**Consultation Response from KC,
Highways Development Management****2023/91413 adj, 25, Richmond Avenue, Fartown, Huddersfield, HD2 2QH****Outline application for erection of residential development****Date Responded:** 2nd October 2023**Responding Officer:** C Dows**Responding Ref:** K5-9NW/21

3. Proposed Site Layout

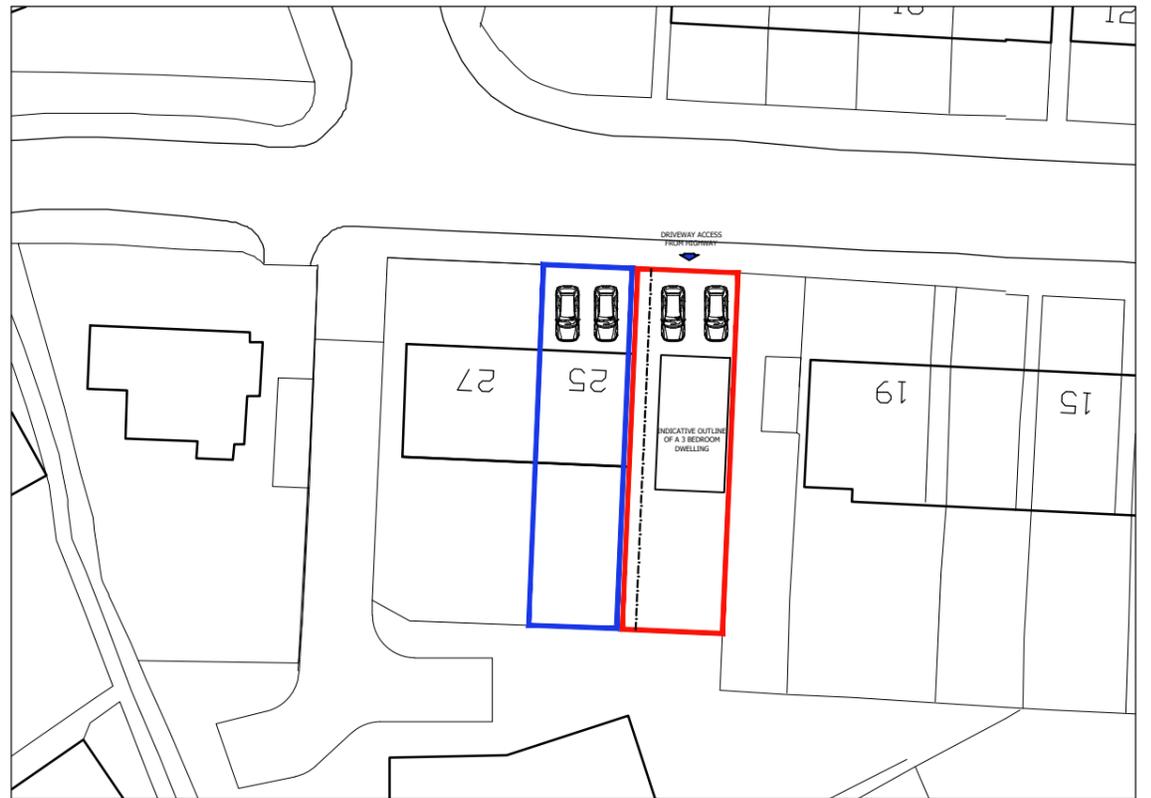
The details submitted indicate a 3-bedroom detached property is proposed. The layout indicates that parking will be provided in the form of parallel parking accessed from and perpendicular to Richmond Avenue, with two spaces for the existing property (number 25) and two spaces for the proposed new dwelling. The parking will be accessed from Richmond Avenue via a vehicular dropped crossing. It is assumed that servicing and waste collection arrangements will be the same as other properties on Richmond Avenue and could be either conditioned or addressed as a reserved matter.

In summary, Access and parking arrangements are considered acceptable. Highways are satisfied that servicing and waste collection arrangements can be accommodated and can be either conditioned or addressed as a reserved matter.

Development works shall not commence until a plan showing details of the proposed vehicular access to the site has been submitted to and approved in writing by the Local Planning Authority. The access shall be constructed as approved, prior to occupation of the development and retained for the lifetime of the development.

Prior to the development being brought into use, the approved vehicle parking areas shall be surfaced and drained in accordance with the Communities and Local Government; and Environment Agencies 'Guidance on the permeable surfacing of front gardens (parking areas)' published 13th May 2009 (ISBN 9781409804864) as amended or superseded; and thereafter retained throughout the lifetime of the development.

Before development commences, details of suitable storage, bin presentation points and access for collection of wastes from the dwelling hereby approved shall be submitted to and approved in writing by the Local Planning Authority. The approved details shall be provided before first occupation and shall be so retained thereafter.
